Application no: **3/2021/0310**

Address: **44 Waddow Grove Waddington BB7 3JL**

Proposal: **Proposed granny annexe to existing private dwelling**

Client: Mr & Mrs Jespson		
Project: Proposed Granny Annexe 44 Waddow Grove Waddington		
Dwg title: Proposed Site Plan		
Scale @ A3: 1:200	Date: 20.03.21	Drawn by: PD
Drawing no. 1228 - 04	Rev. -

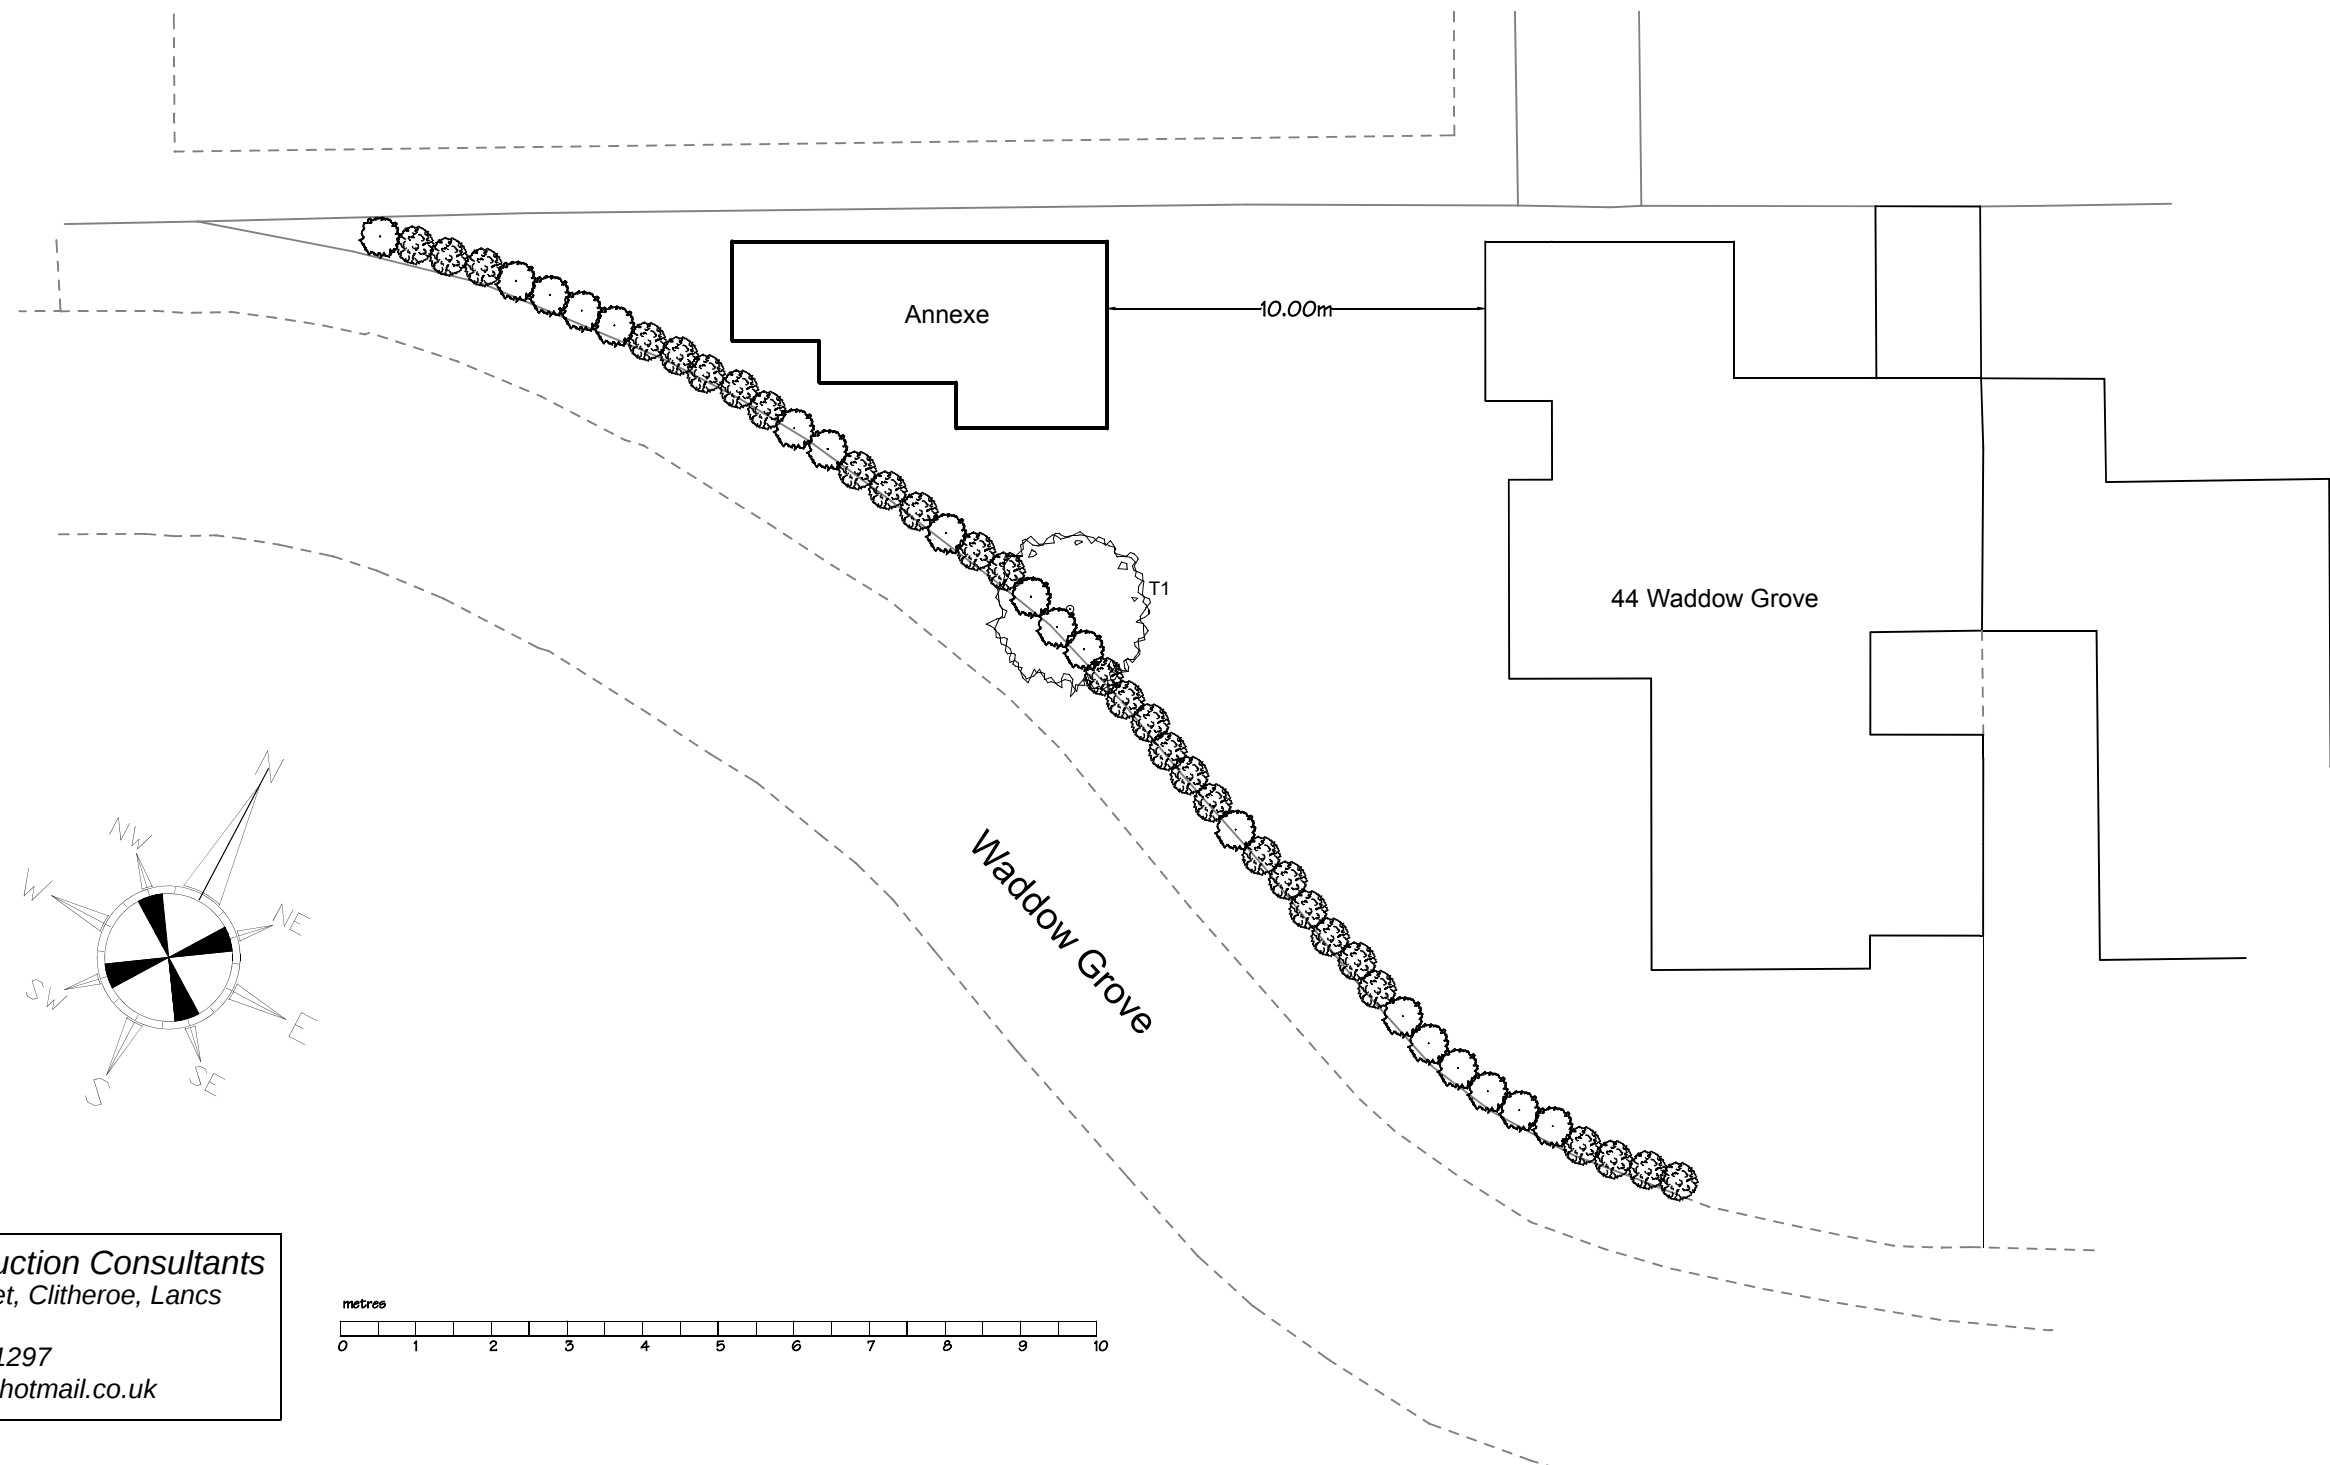
Please note, the design statement demonstrates an area of hardstanding from the existing view to the Southern boundary whilst looking East. Whilst this area of hardstanding is not included within the submitted proposal, should this area of hardstanding be used for vehicular purposes then a vehicular dropped crossing must be installed under Section 184 of the Highways Act 1980.
